From: Michael Eastham <Michael.Eastham@arun.gov.uk>
Sent: 07 December 2020 08:08
To: Planning.Responses <Planning.Responses@arun.gov.uk>
Subject: FW: *EXTERNAL: A/179/20/RES - Land South of Water Lane, Angmering

Please upload onto Ocella the email below which is a further consultation response from **WSCC Fire & Rescue Service** to reserved matters application **A/179/20/RES**.

Please see the email below from Sean Havis at BDW and find attached an amended plan for reserved matters application **A/179/20/RES** relating to the culverted embankment on Land South of Water Lane, Angmering.

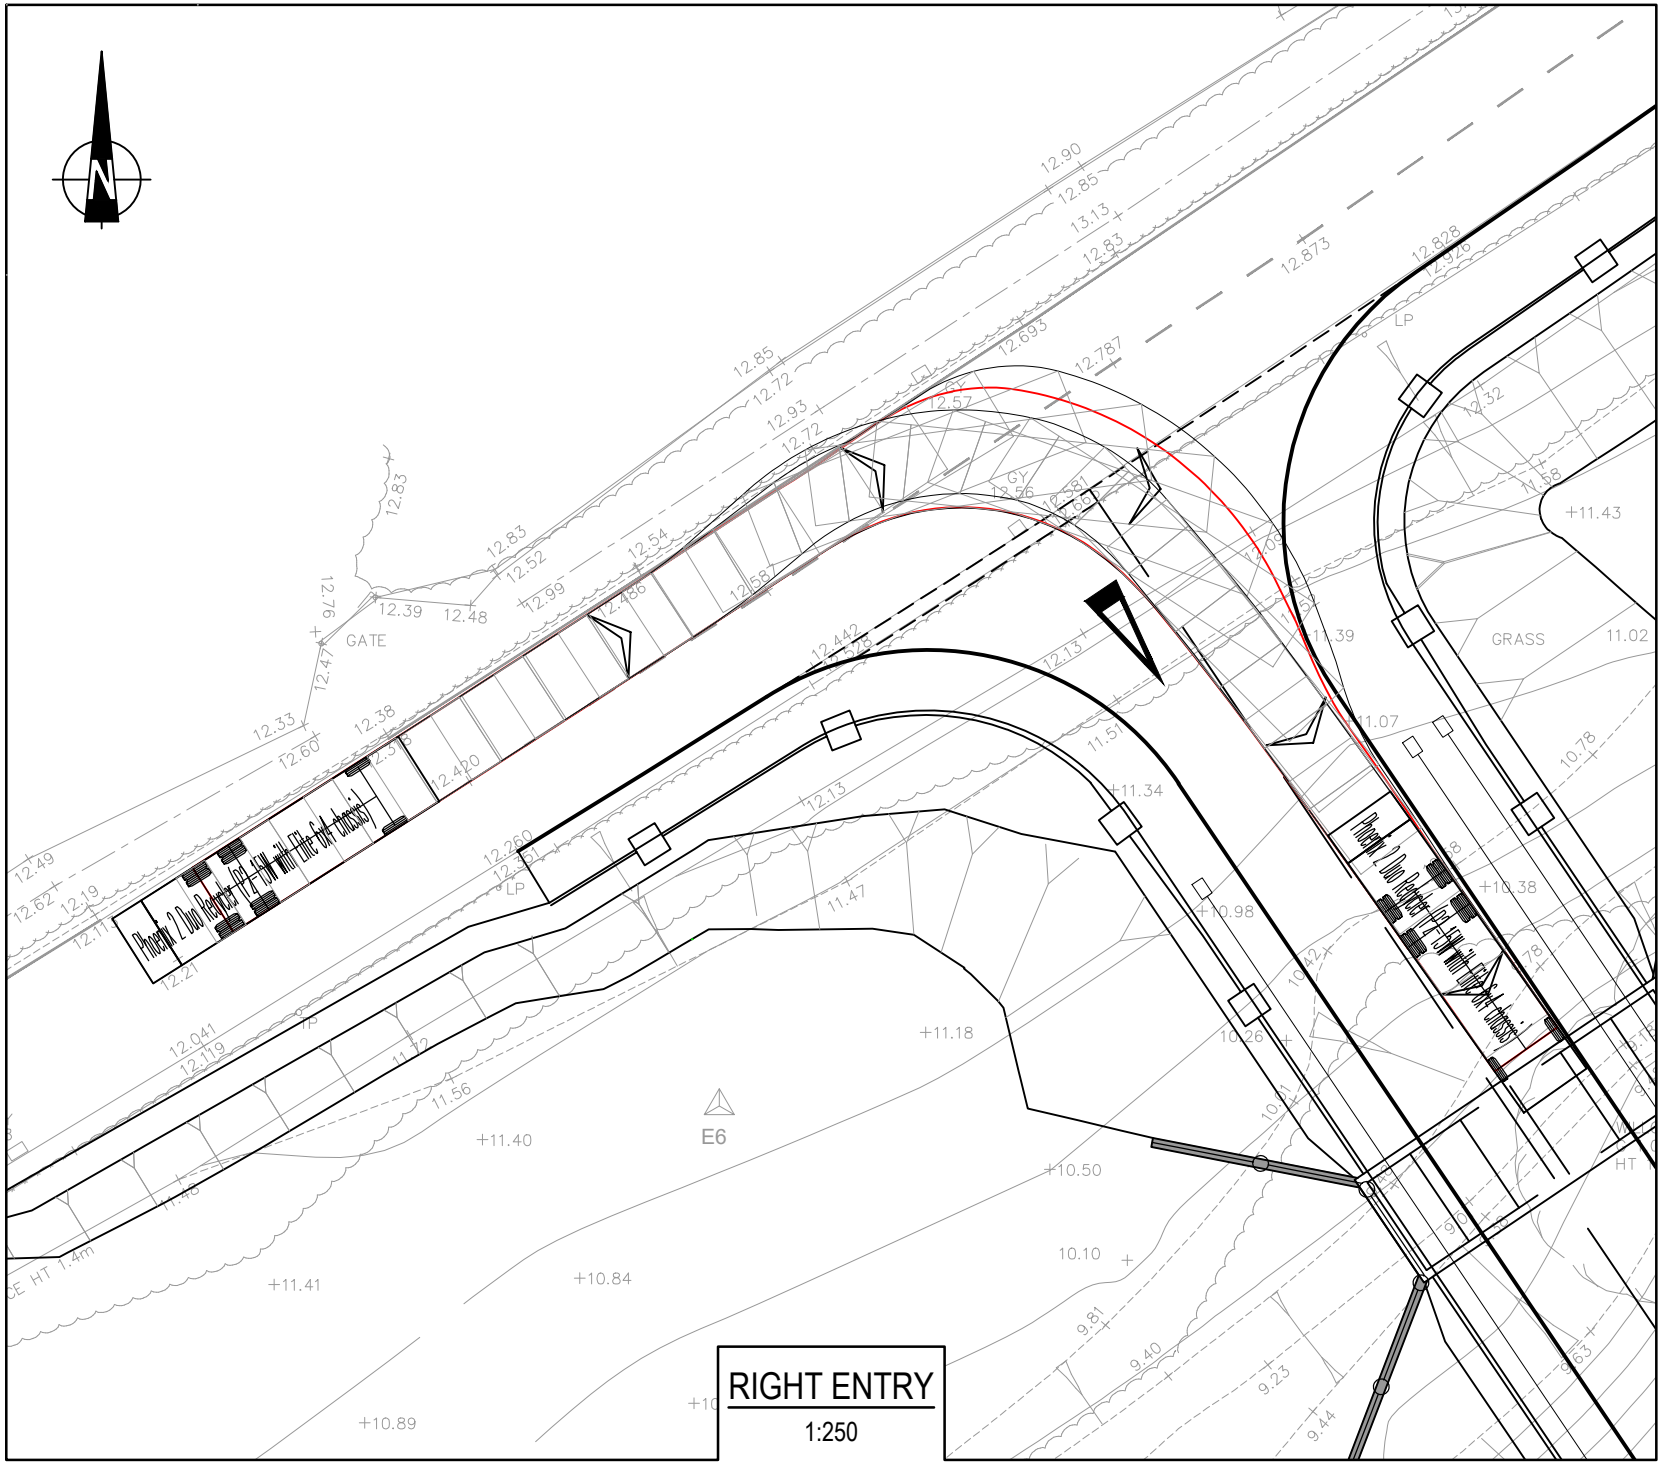
Evidence would be required that there is sufficient access width for a fire appliance to access the site. The road would need to be sufficiently wide enough to allow a fire appliance to gain access with a minimum width of 3.7 metres and capable of withstanding 12 to 17 tonne axial weight.

Evidence would be required that there is sufficient access width for a fire appliance to access the site. The road would need to be sufficiently wide enough to allow a fire appliance to gain access with a minimum width of 3.7 metres and capable of withstanding 12 to 17 tonne axial weight.

Thanks you for the response to our consultation, the plan does demonstrate suitable access onto the site, however there has not been a site layout plan submitted to allow the Fire Service to assess the access to all premises,. This I assume will be submitted at a later date as this application was for access only.

In regard to the other two queries from the Local Highway Authority and WSCC Fire & Rescue Service, please find the attached revised plan (General Arrangement - 46353_2002_020_A) illustrating the crossing over Water Lane connecting into the footway/cycleway running north and east. The attached plan also demonstrates that the width of the carriageway is 6m, significantly exceeding the 3.7m requirement. I can also confirm that the culvert will be constructed to be capable of withstanding 12 to 17 tonne axial weight.
